**Item No.**                    **Report of the Head of Planning, Transportation and Regeneration**

**Address**                    178 AYLSHAM DRIVE ICKENHAM MIDDLESEX

**Development:**            Conversion of garage to habitable room including extension of front porch

**LBH Ref Nos:**            **71302/APP/2021/1824**

DRAWING TITLE:
Existing & Proposed Ground Floor Plan

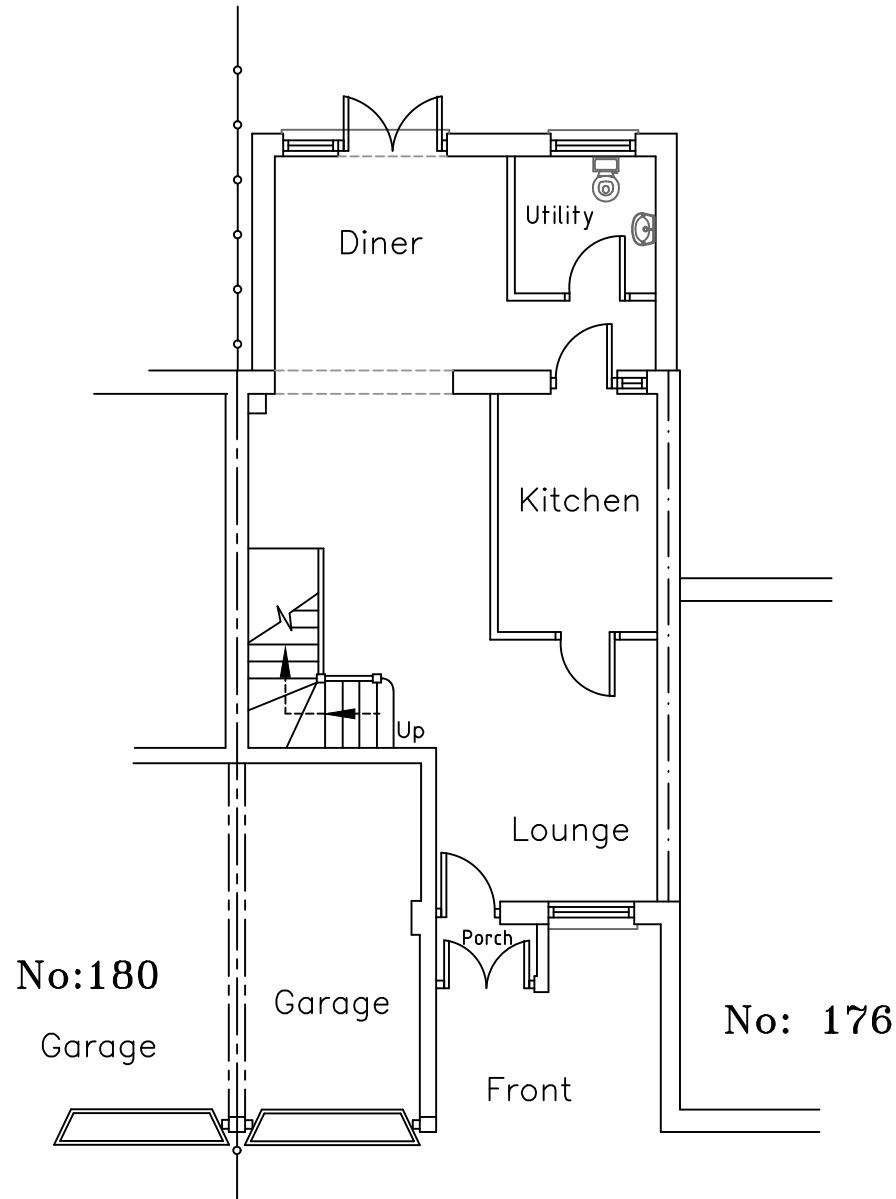
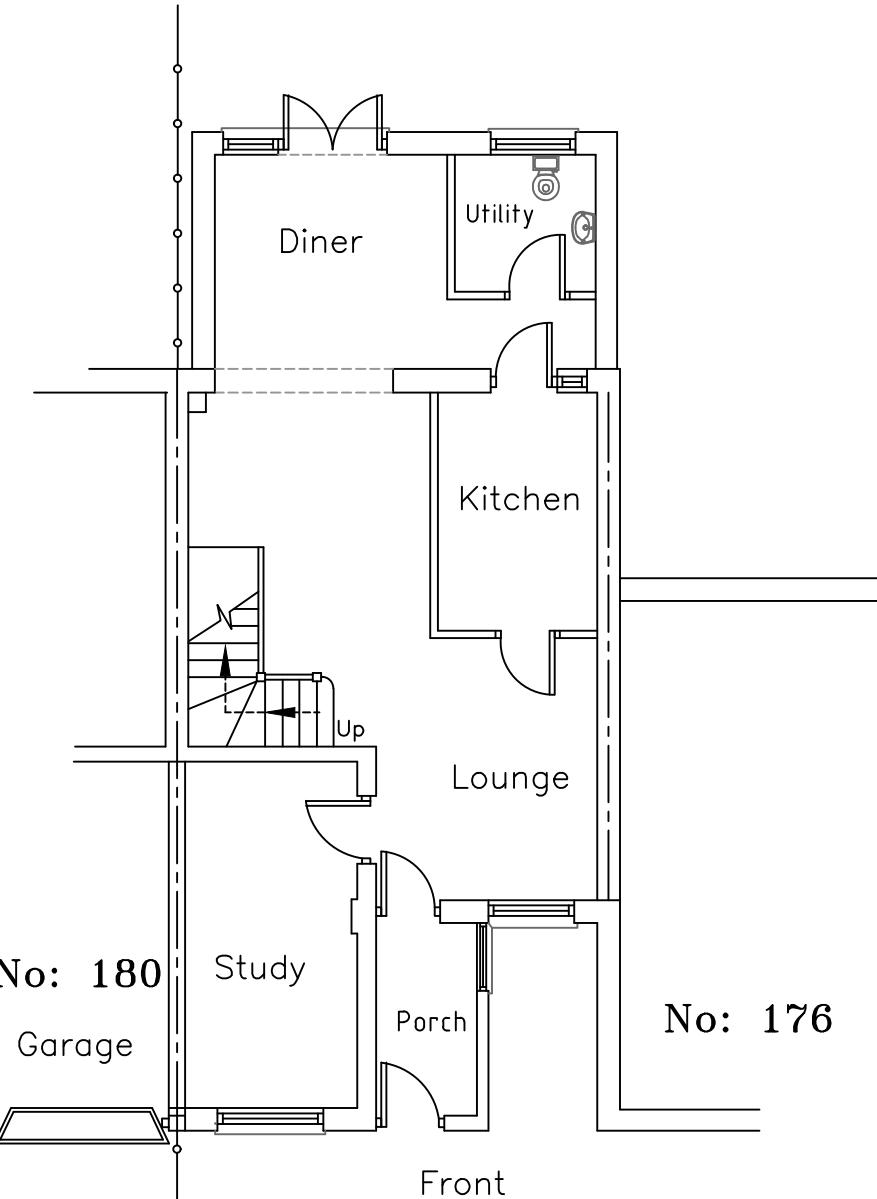
The proposal involves conversion of the existing garage to habitable room for use as a study. The works will be internal to the dwelling but there will be a change from the garage door to windows on the exterior. There is no objection to the works involved with conversion of the garage to habitable use. In terms of design and appearance, the conversion would not cause harm to the street scene or damage the character of the surrounding neighbourhood.

The impact on the loss of garage will be little as the size of the garage is too small to fit a modern vehicle and the garage was most likely used for storage space. The dwelling will still retain an off-street parking space to the front. Therefore parking will not be affected and the development is in accordance with Policy DMT 6 A) of the Local Plan Part 2.

DRAWING TITLE:  
Existing & Proposed  
Side Elevations

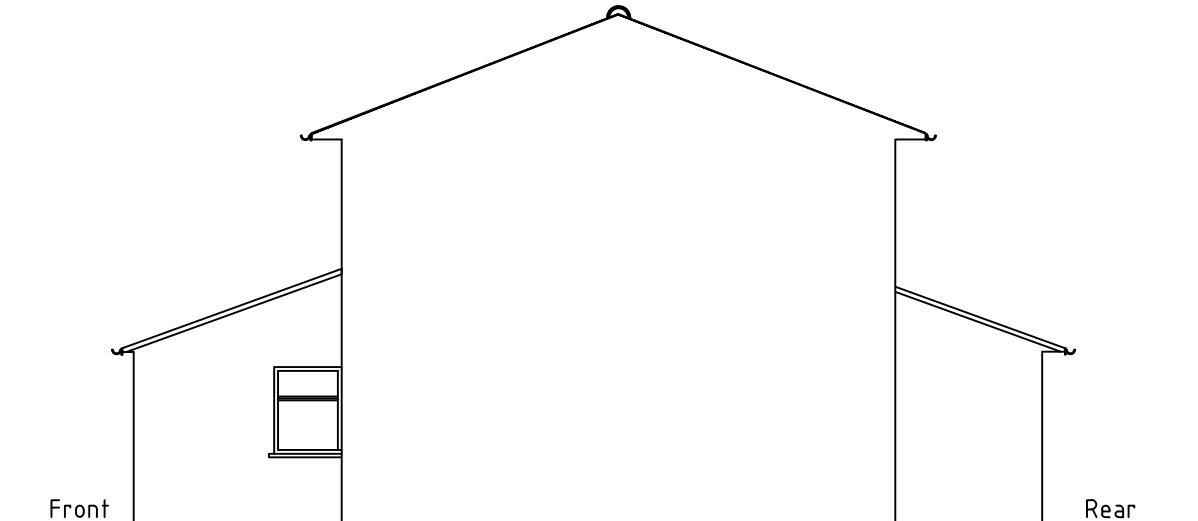
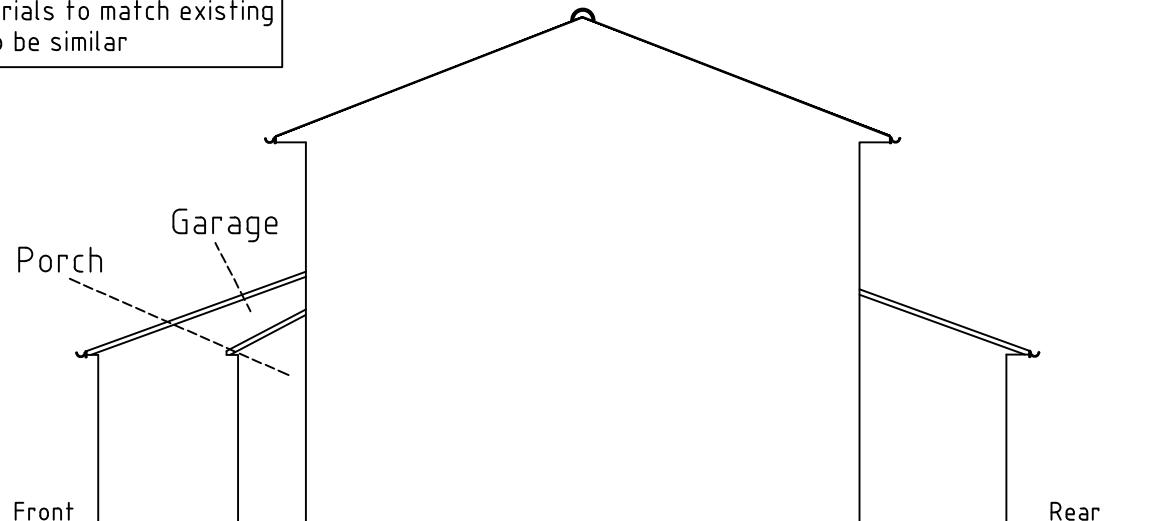
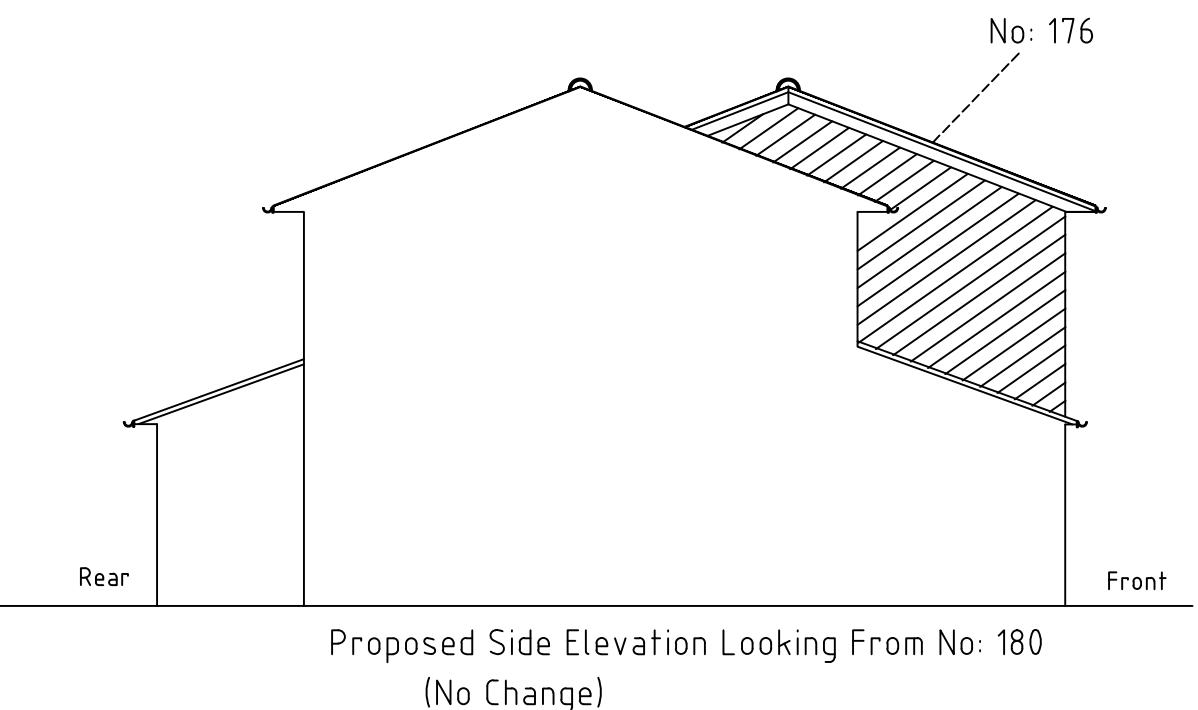
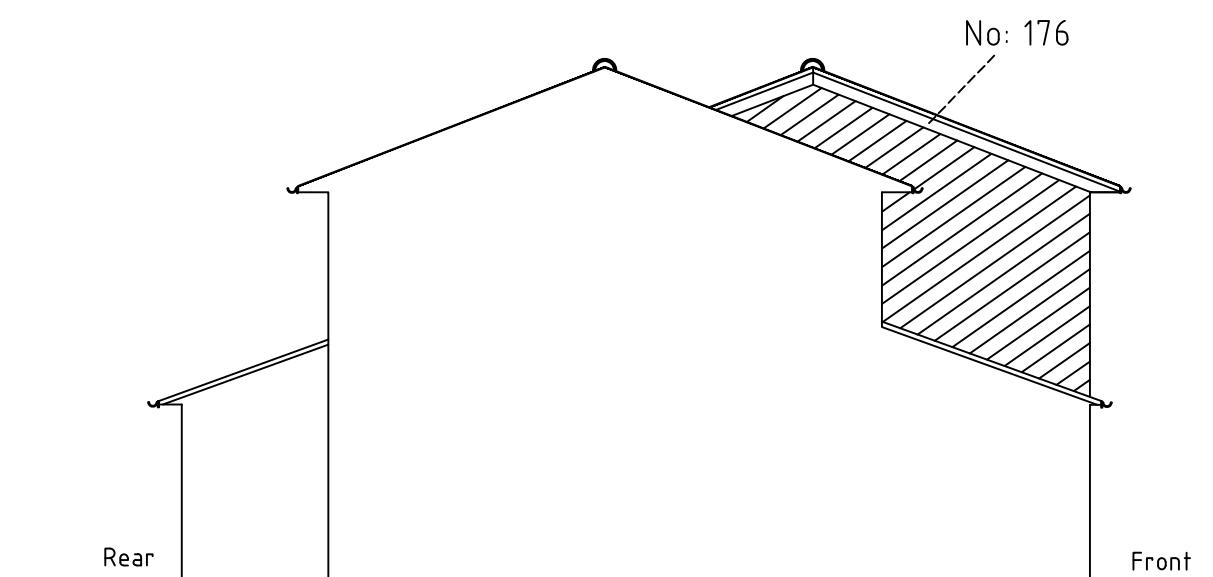
There is already an existing porch, which is proposed to be extended up the the depth of the existing garage wall by 2 metres with a sloped roof at 3 metres. The porch will not

dominate the character of the street as the porch will not extend across the whole frontage of the property. Although, the porch exceeds the permitted volume of three square metres, it will still remain subordinate to the building and considering the above, the front porch will still retain over 25% of the front garden space. There will be no impact harming the outlook or daylight of the neighbours either side of the application site. Also, as the garage will be converted and a new window inserted into the front elevation, the porch will create a positive outlook and appearance on the street scene. There are also other examples of property frontages on Aylsham Drive which have a similar look with the front door matching the depth of the converted or existing garage, these properties include no. 81, 168 and 335 Aylsham Drive, where planning permission was granted for similar works including a front porch extension.
